COUNTY OF HARNETT LAND USE APPLICATION

Re: Status of Improvement Permit Application # 06-50014610 Lot 98 Forest Oaks
06-50014611 Lot 99 Forest Oaks

**Re: Status of Improvement Permit Application #06-5-14610 - Lt 98 Forest Oaks
#06-5-14611 - Lt 99 Forest Oaks**

IMPROVEMENT PERMIT 23038

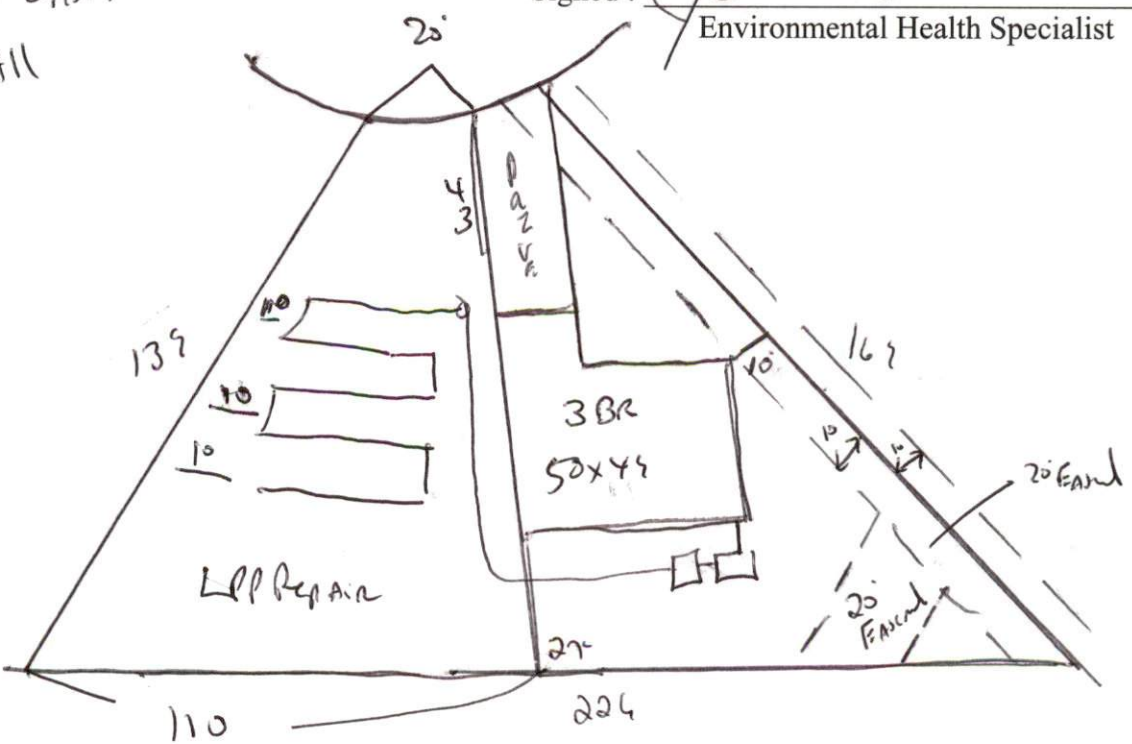
NOTE house Nor Drive way
 can be with in Area marked
 septic system or Repair Area.

- 1. Property lines/corners not marked or labeled
- 2. House corners not marked or labeled
- 3. Directions not clear to property
- 4. Property needs brush or vegetation removed
- 5. Backhoe pits required
- 6. Other - Move house site back as shown on attached sheets.
